ADC PARKS & GREENSPACE ARBORICULTURE CONSULTATION

PLANNING APPLICATION: AW/185/12/T

ADDRESS: Little Turrets 89 The Fairway Aldwick PO21 4BX

BRIEF DESCRIPTION: Cut 6 branches back by 10m to 1 No Conifer tree

AW/185/12/T

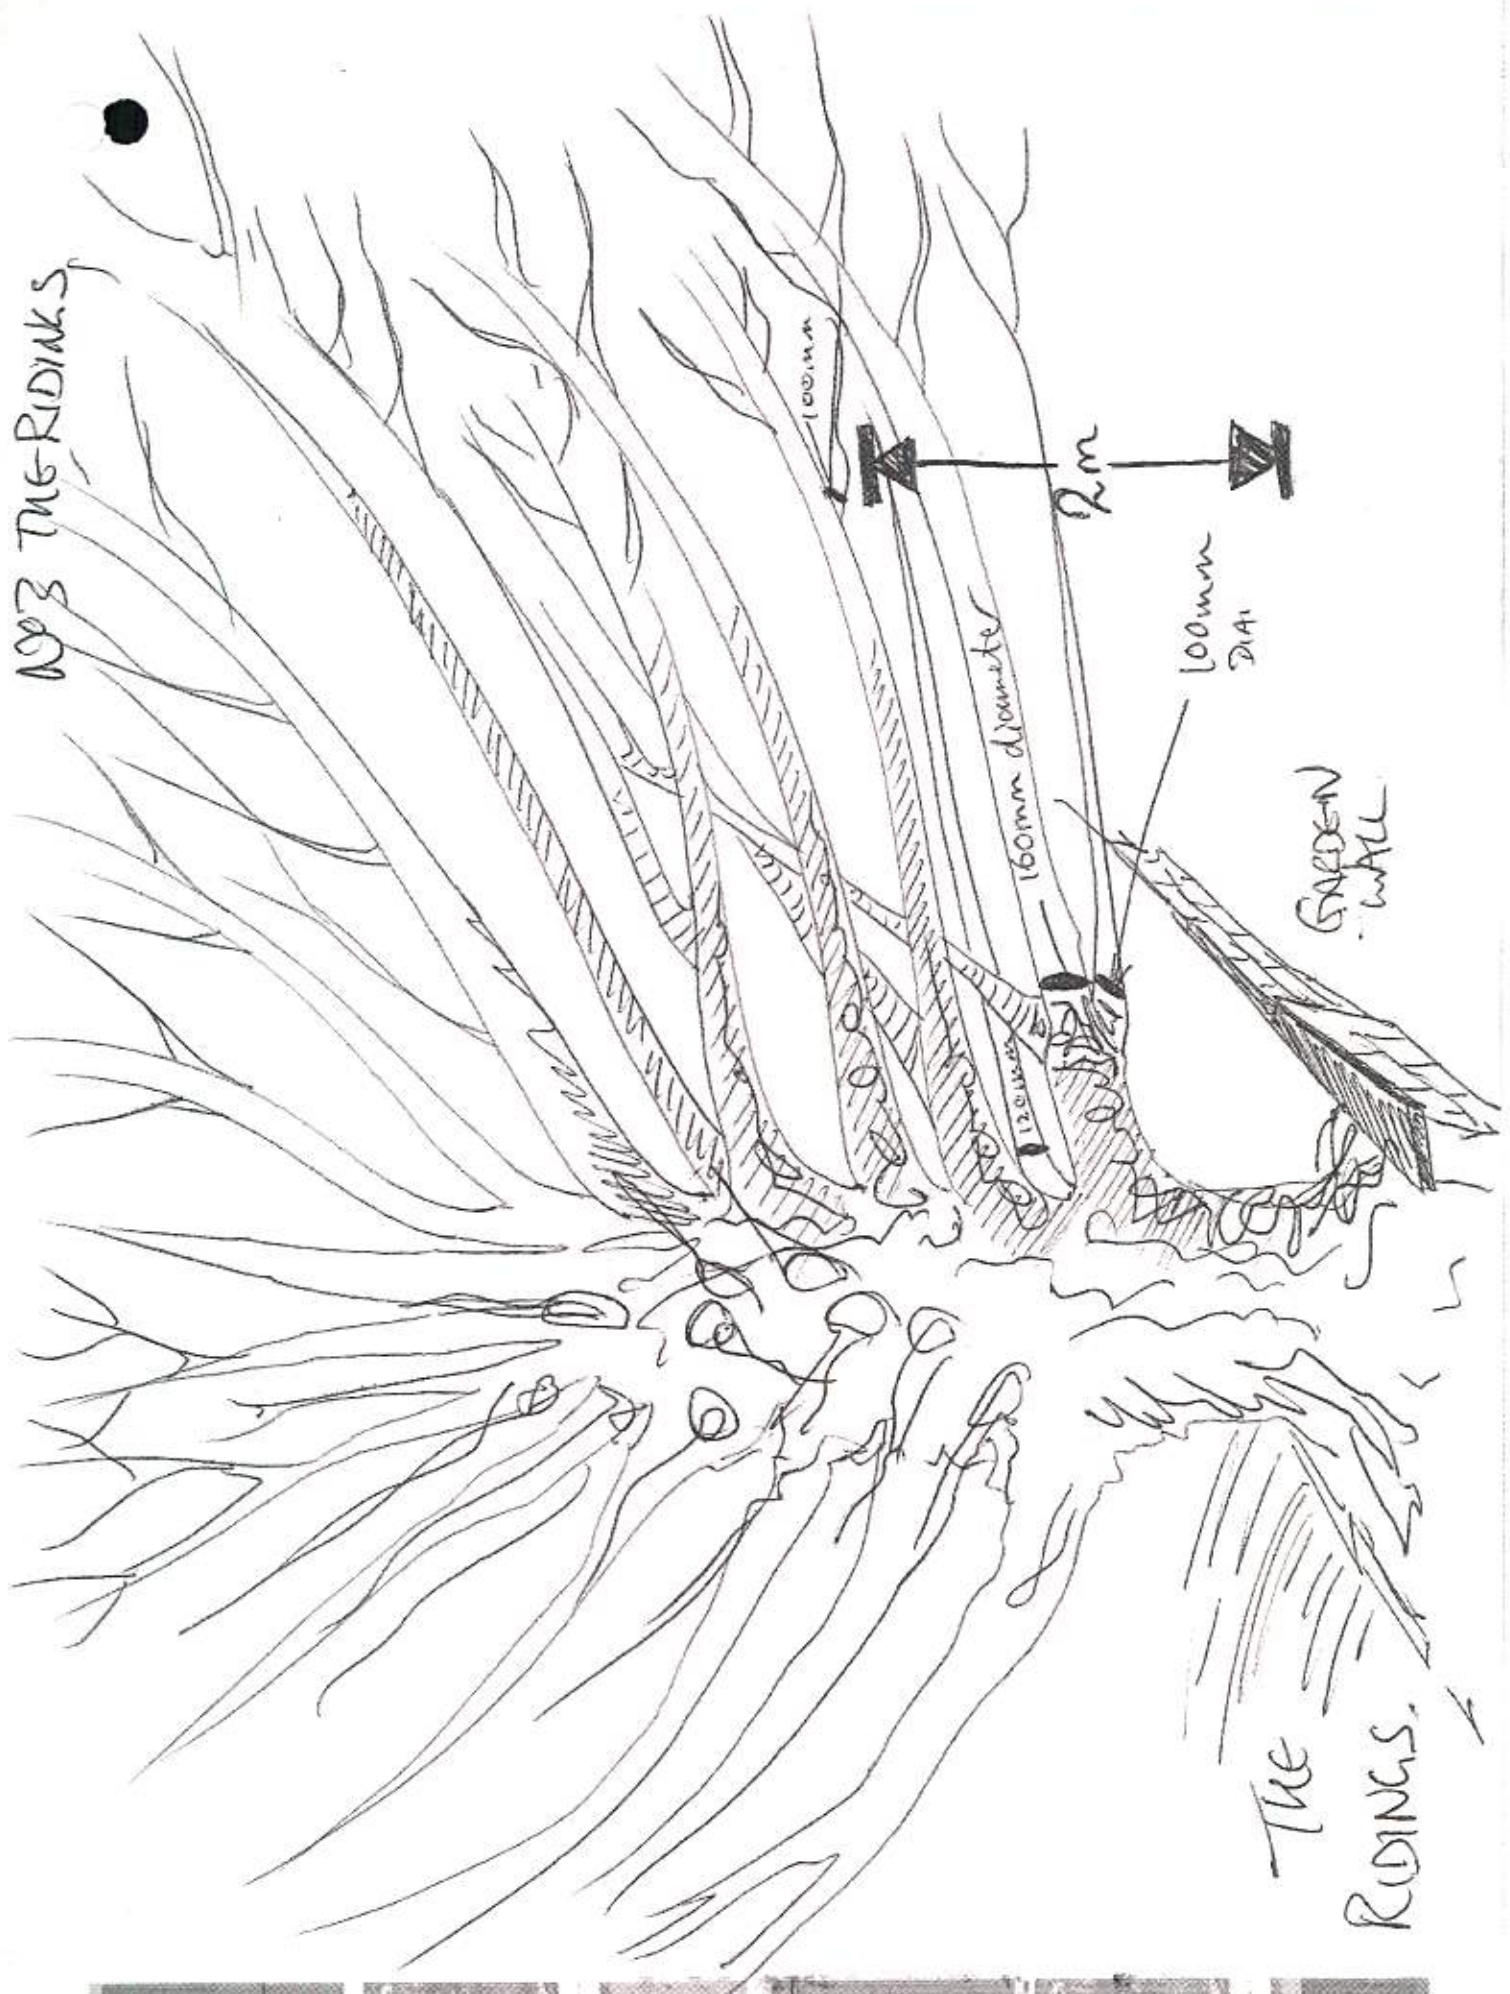
I have inspected the Monterey Cypress and understand the need for lower branch removal to facilitate access beneath its crown. There is scope to allow for some of the lower branches to be cut back to a minimum wound size without it affecting the remainder green outer shell. A suggested condition is provided below;

1) Six lowest limbs varying in diameters of 100mm to 160mm to be removed ONLY from the garden side to create a 2m clear distance from the ground to the next whorl of branches.

2) Wounds must be kept minimal by target pruning to the bark branch ridge/collar and cut to produce a smooth flat surface.
